**Memorandum  
Department of Planning and Urban Development  
Planning Division**

**To:** Chair Morrisette and Members of the Portland Planning Board  
**From:** Jean Fraser, Planner  
**Date:** Prepared on: June 8, 2012  
 Prepared for: June 12, 2012 PB Workshop  
**Re:** **Fore India Middle, LLC, Opechee Construction Corporation  
 203 Fore Street (part of the redevelopment of 207-209 Fore Street)**

2 INDIA STREET BUILDING ELEVATION
 A6 1/16" = 1'-0"

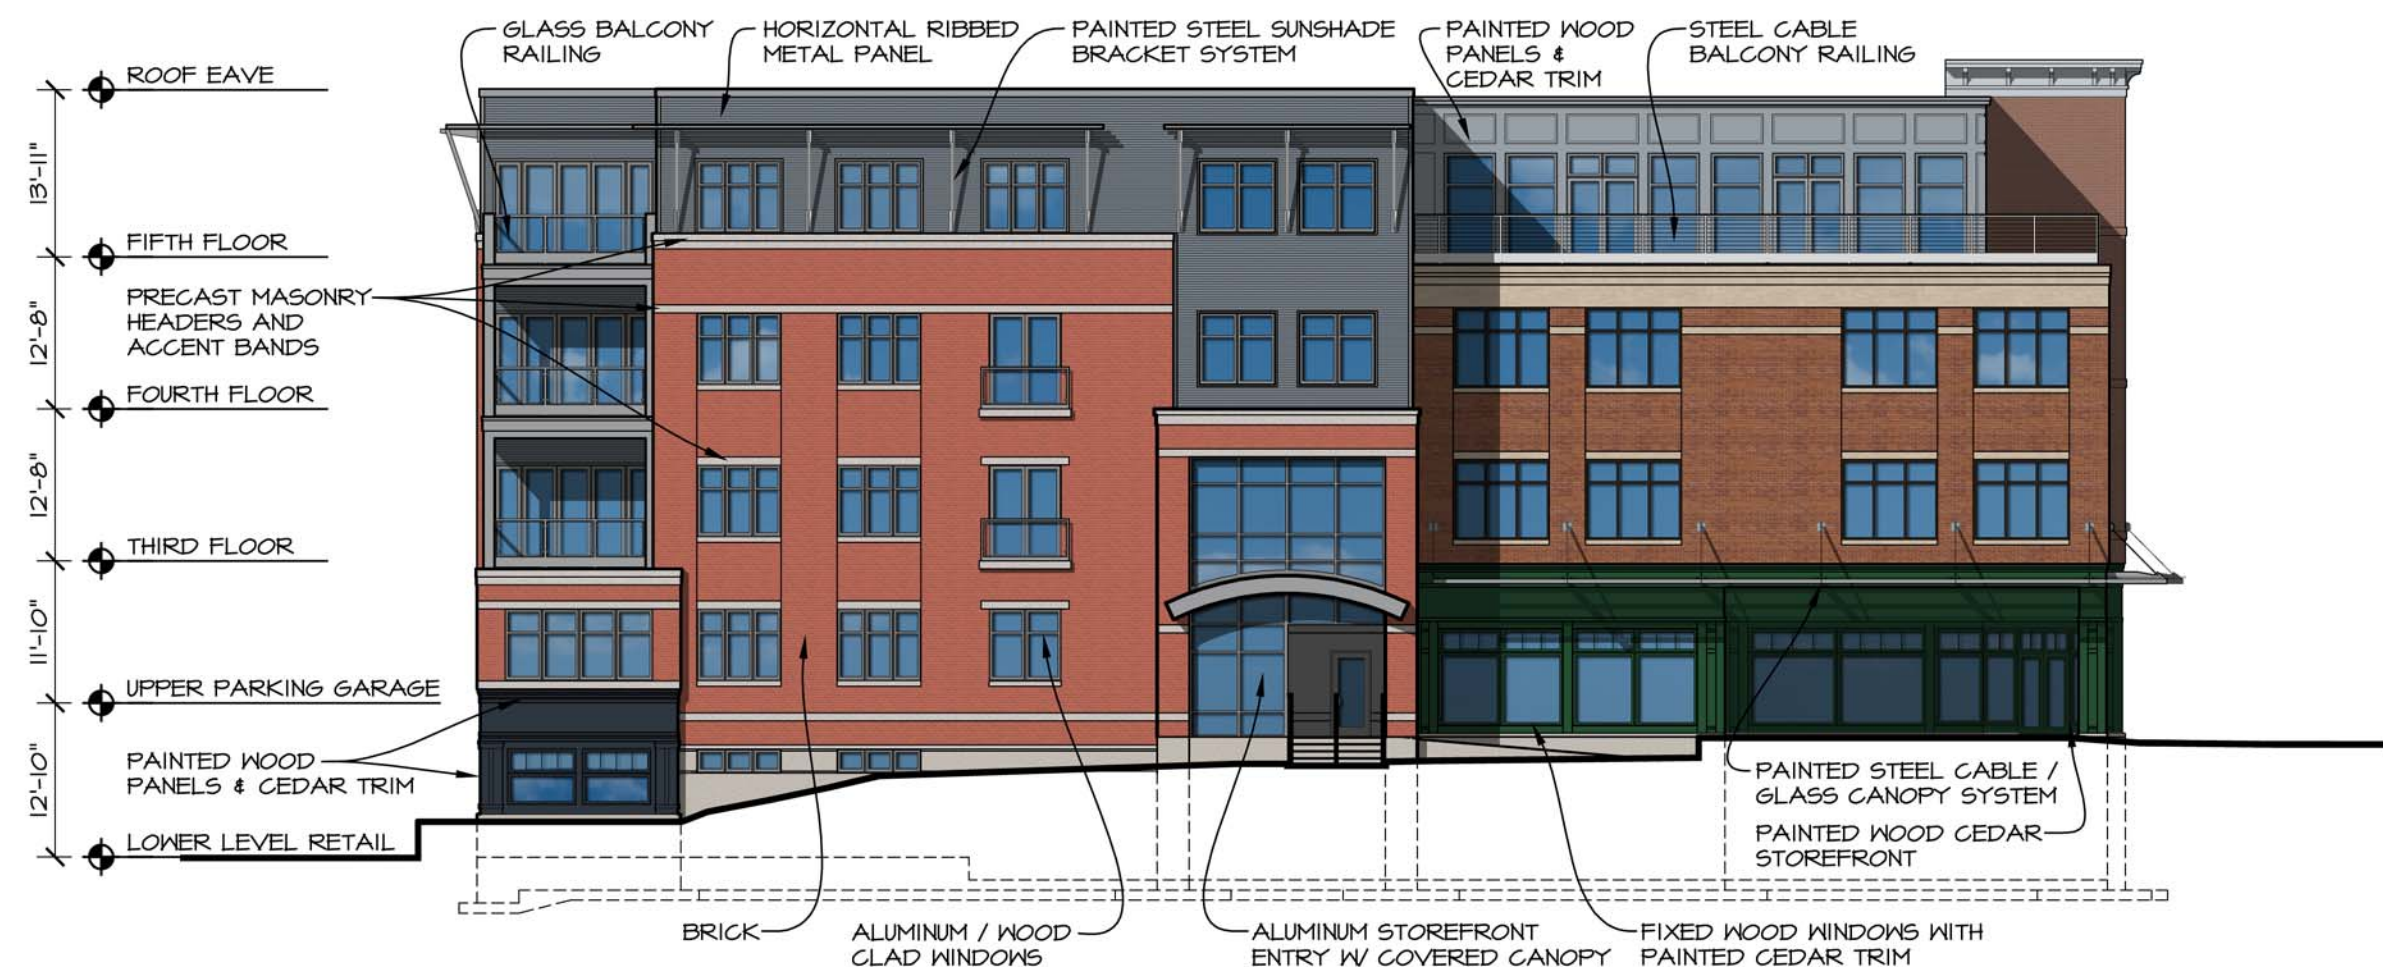
- The proposed building is set back some 35 feet from Fore Street near the corner with India Street (see photo right). The Landscaping Plan ([Attachment J.8](#)) and rendering ([Attachment J.20](#)) shows this as a sunken area reached by steps and hidden by shrubs- creating an area that may not be visible from the public areas around it. Staff have suggested in the Design Review Memo ([Attachment 7](#)) that this area may be more successful if designed as an attractive and more open mini-plaza with seating. The City Arborist has also suggested curbed planters could be incorporated ([Attachment 6](#)).

- Integration of the new building (4 stories above Middle Street at this location- see elevation in Attachment J.19) where it meets the steps down to the hotel (just beyond the existing 2 story building as seen in the photo at right) appears unresolved;
- Reconsider landscape design of the space at corner of Fore and India, where the building is set back by about 35 feet, to address CPTED concerns (see discussion above) and consider opening out to create a mini plaza with seating. It should be noted that the setback of 35 feet does not meet the zoning requirement of 5 feet maximum setback and the Planning Board is requested (Attachment B) to grant a waiver for the larger setback.

MIDDLE STREET LEVEL FLOOR PLAN
SCALE: 3/64" = 1'-0"

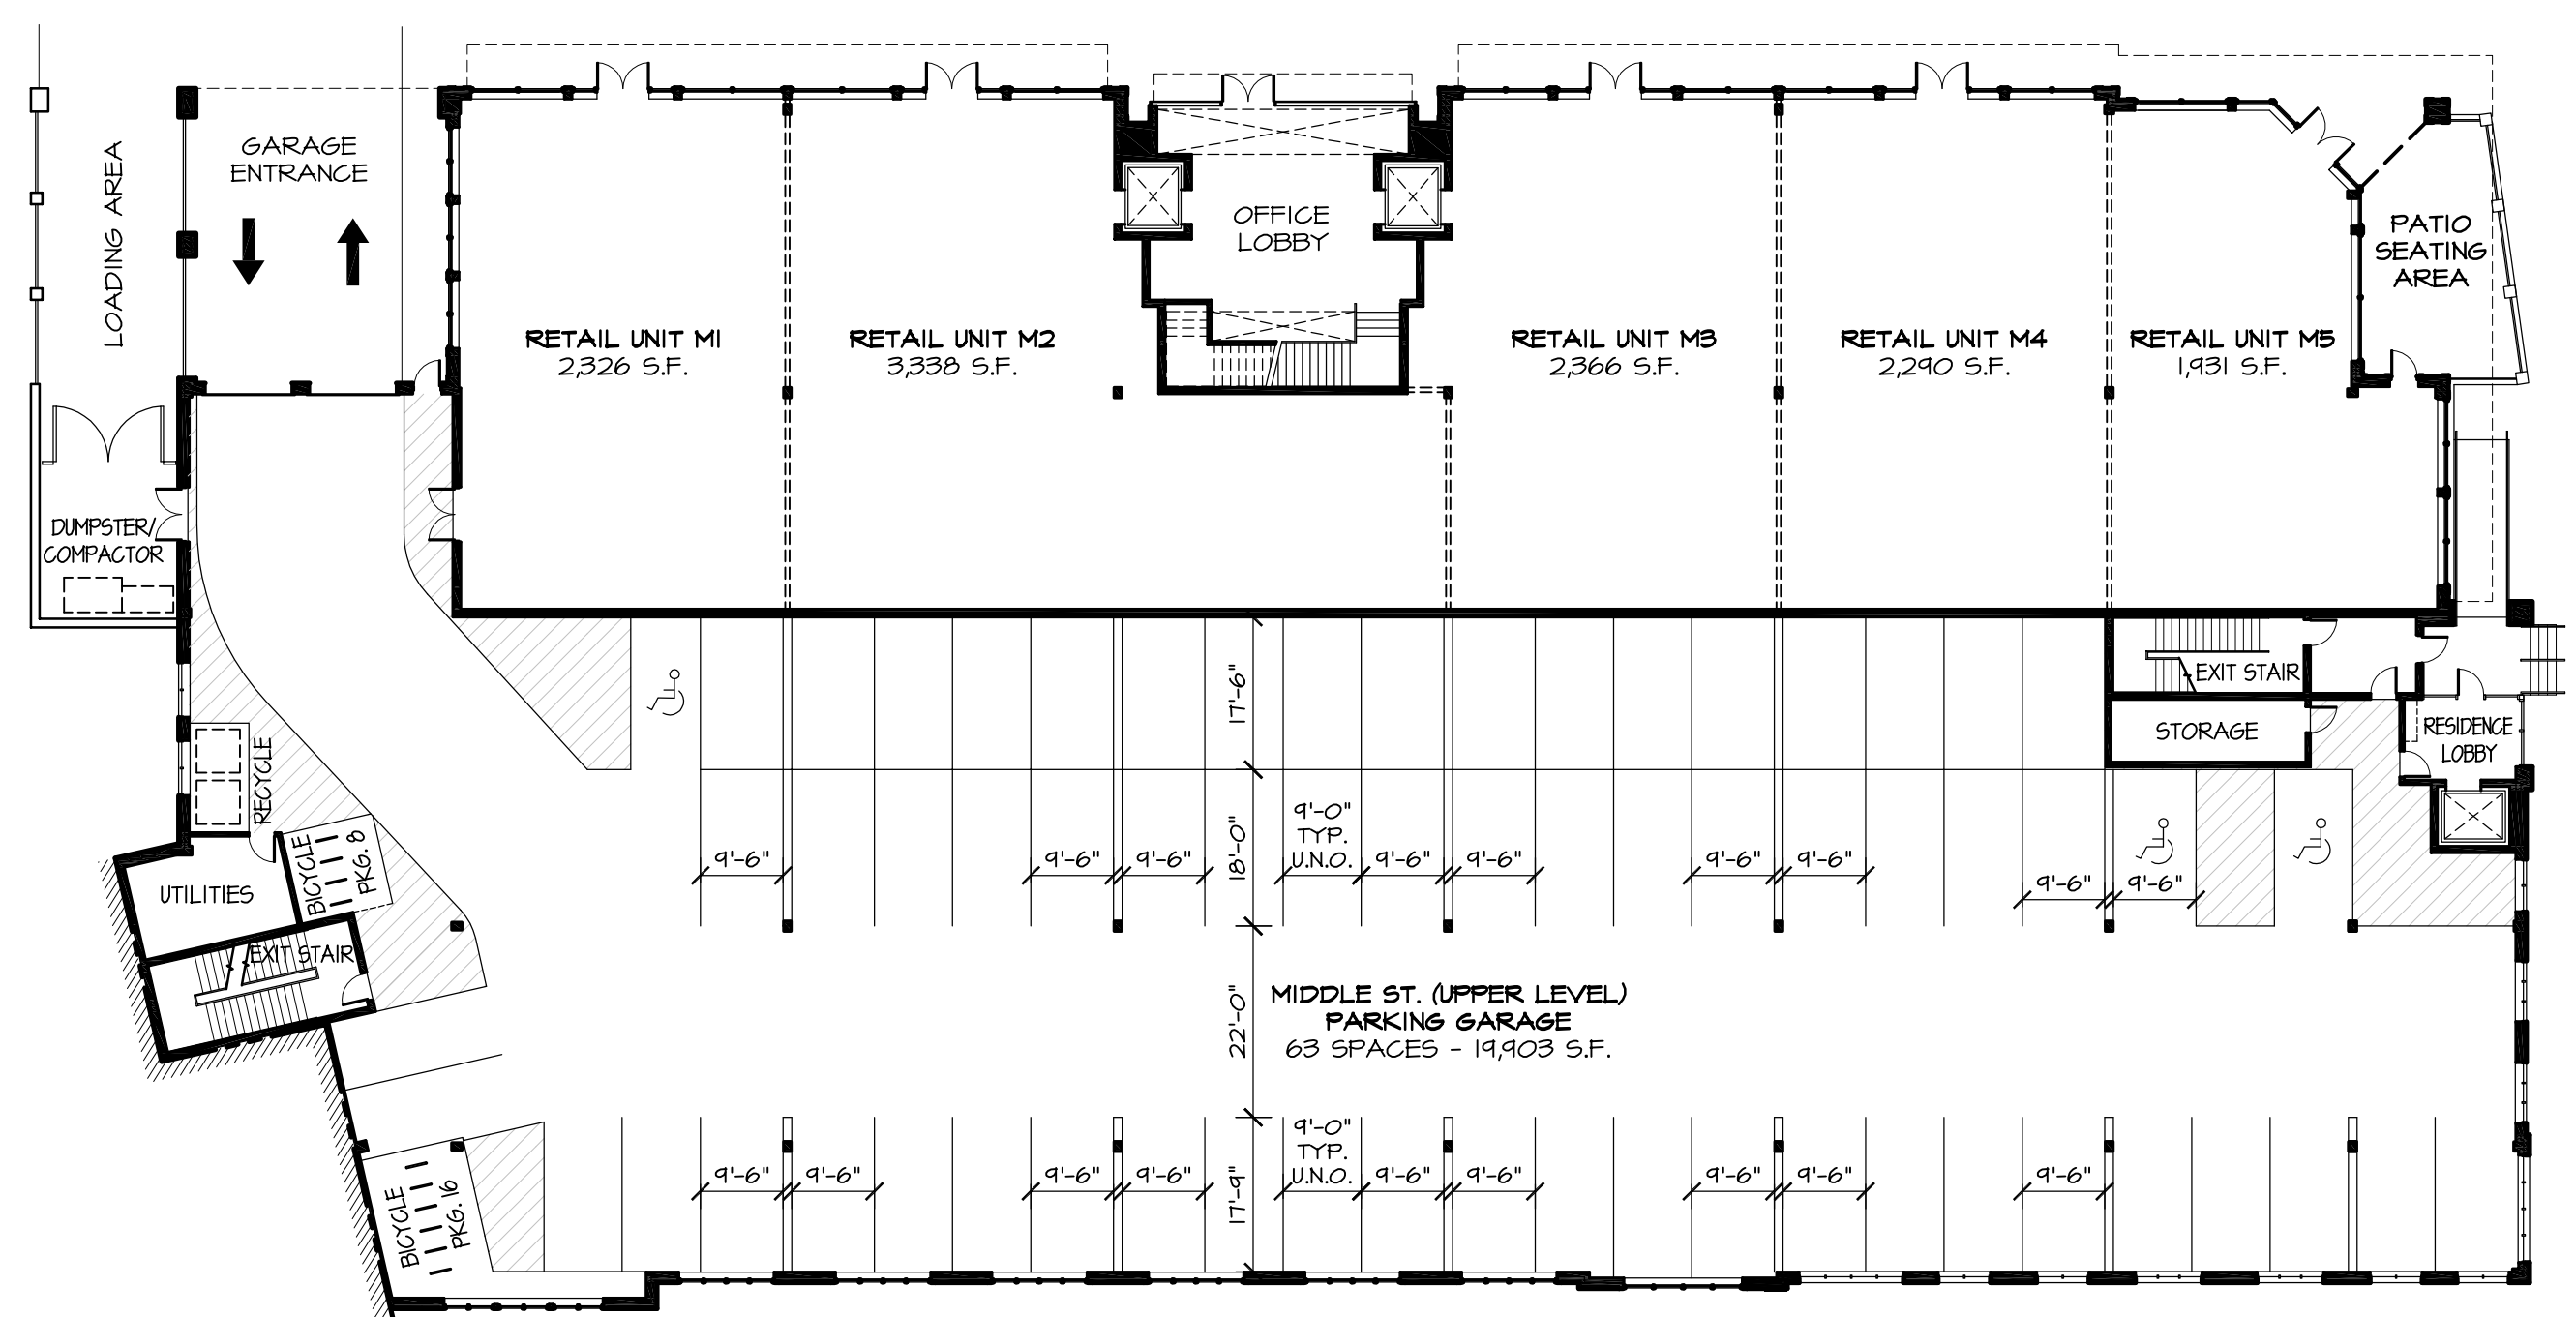
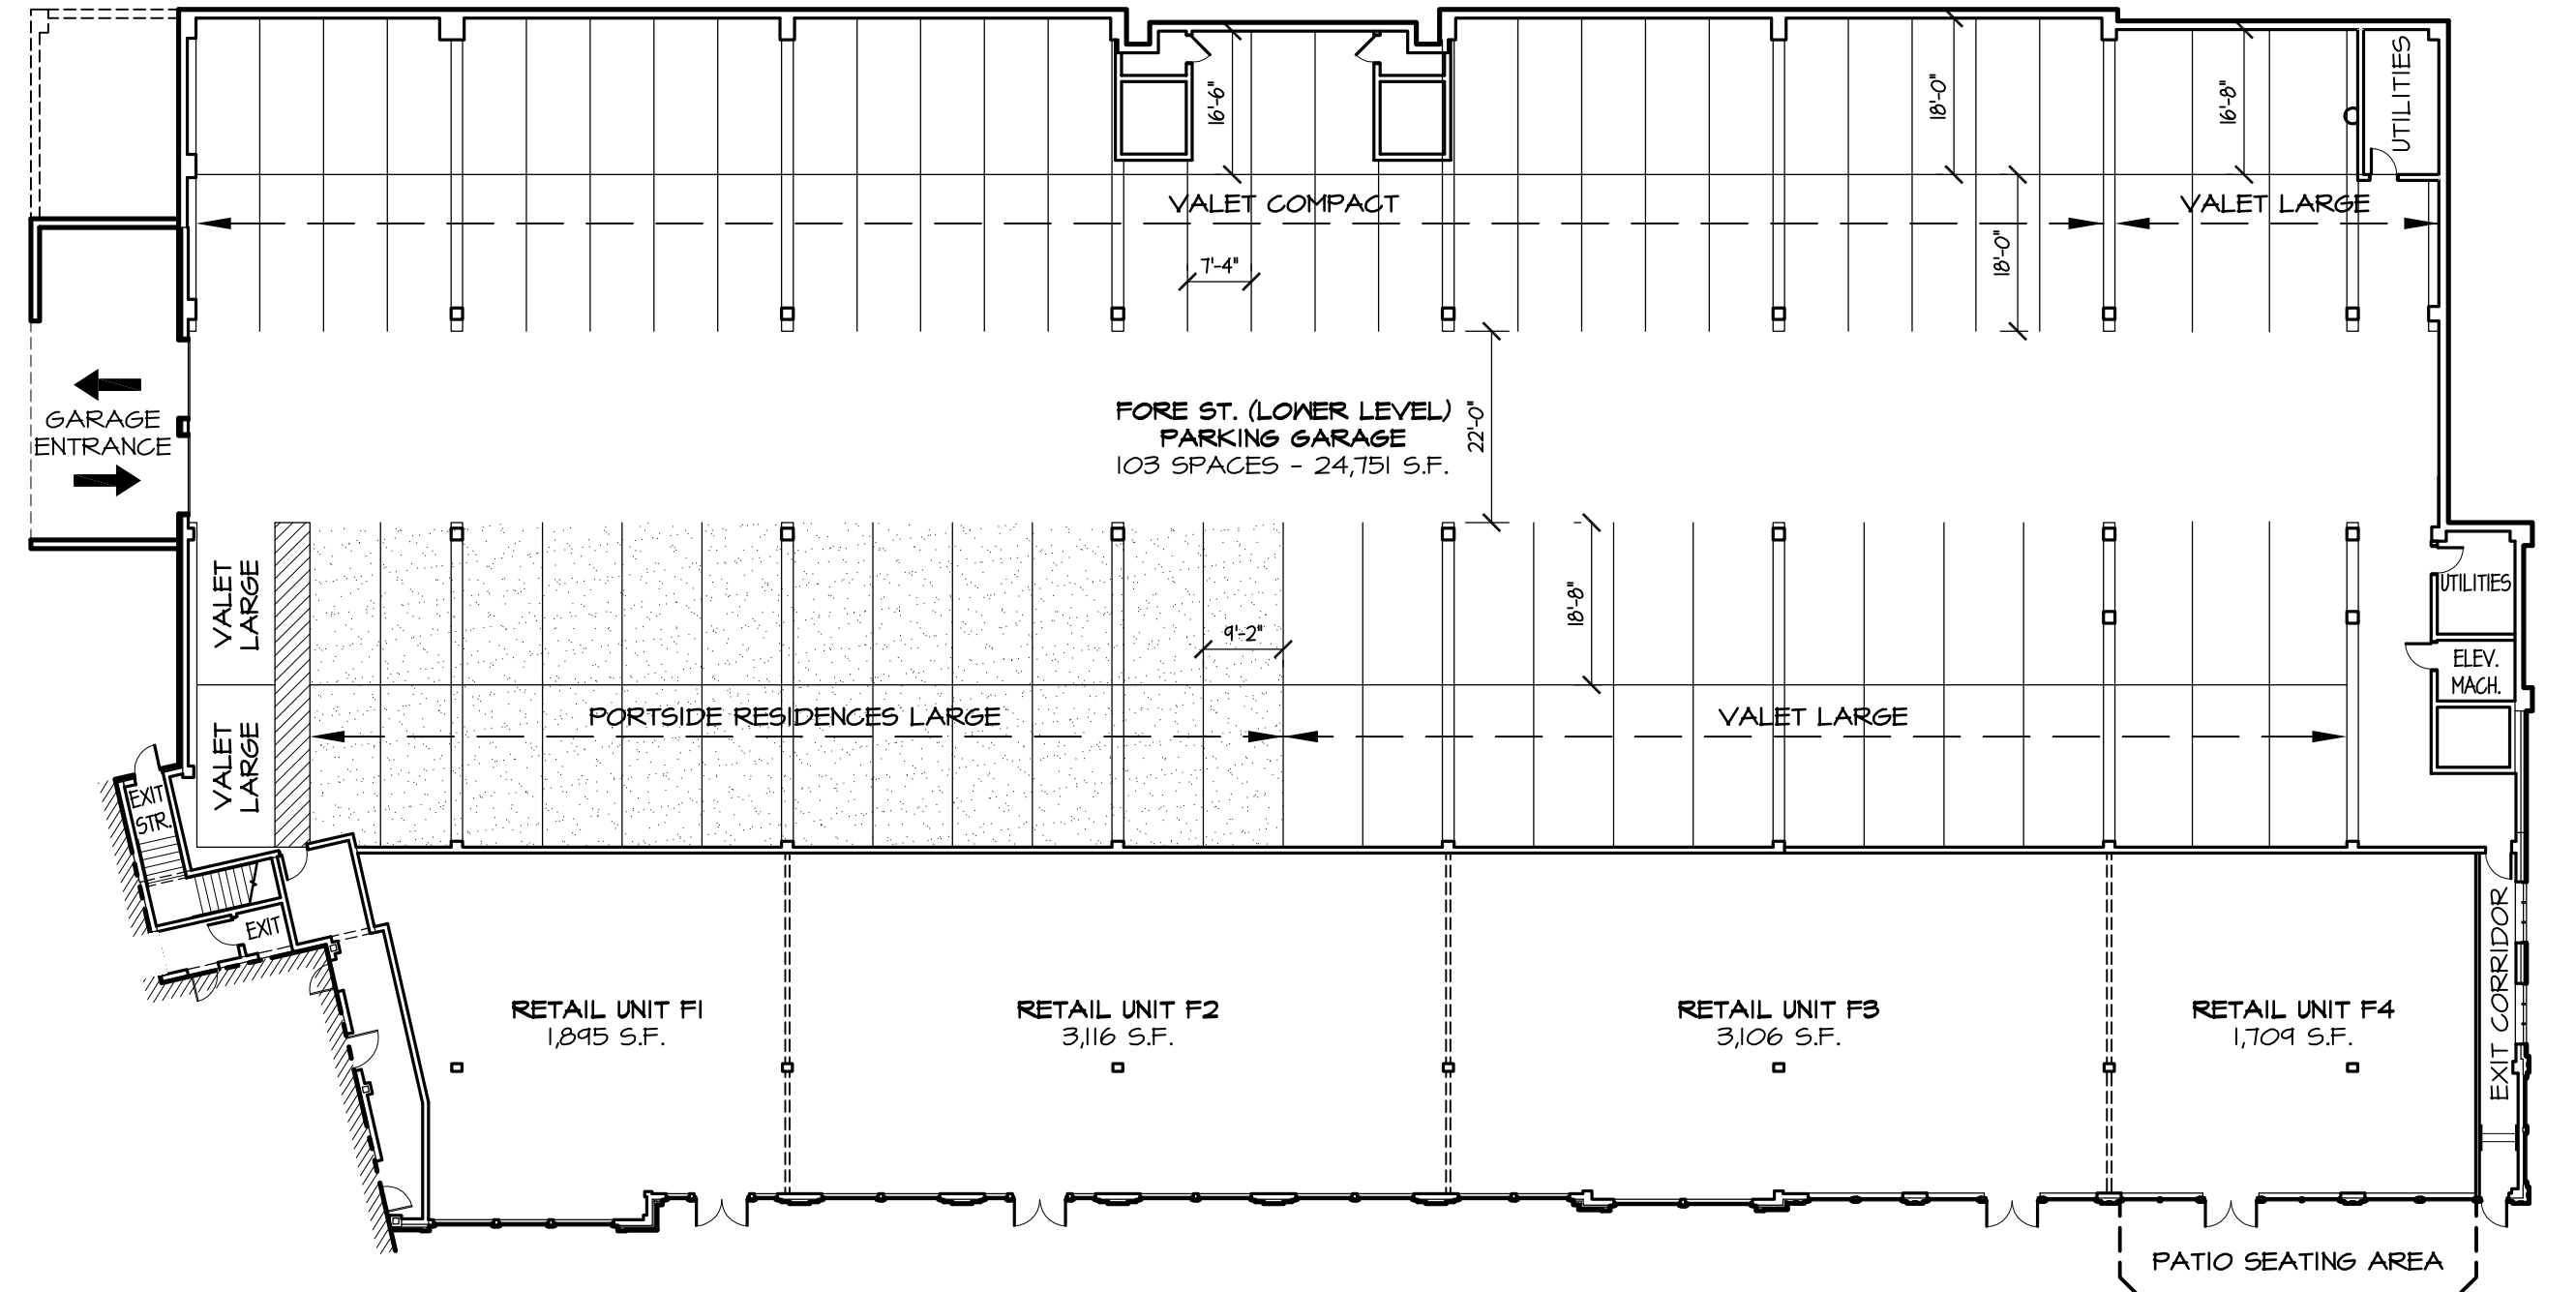
The Middle Street driveway access into the parking garage is proposed to be 42 feet wide, which includes a 24 foot wide access to the parking garage, a 15 foot wide loading bay and a 3 foot support column between these two. The proposed width exceeds the technical standard of 36 feet and the applicant has submitted a waiver request (Attachment B) for the wider curb cut. Although the radii are designed to minimize the length of the curb cut that pedestrians must cross, staff remain concerned about pedestrian safety as confirmed by Tom Errico's comments (Attachment 2):

The driveway width exceeds City standards and accordingly will need a waiver from the City's Technical standards. I support a waiver, but would like the applicant to provide recommendations on how best to design the driveway for optimal pedestrian safety.
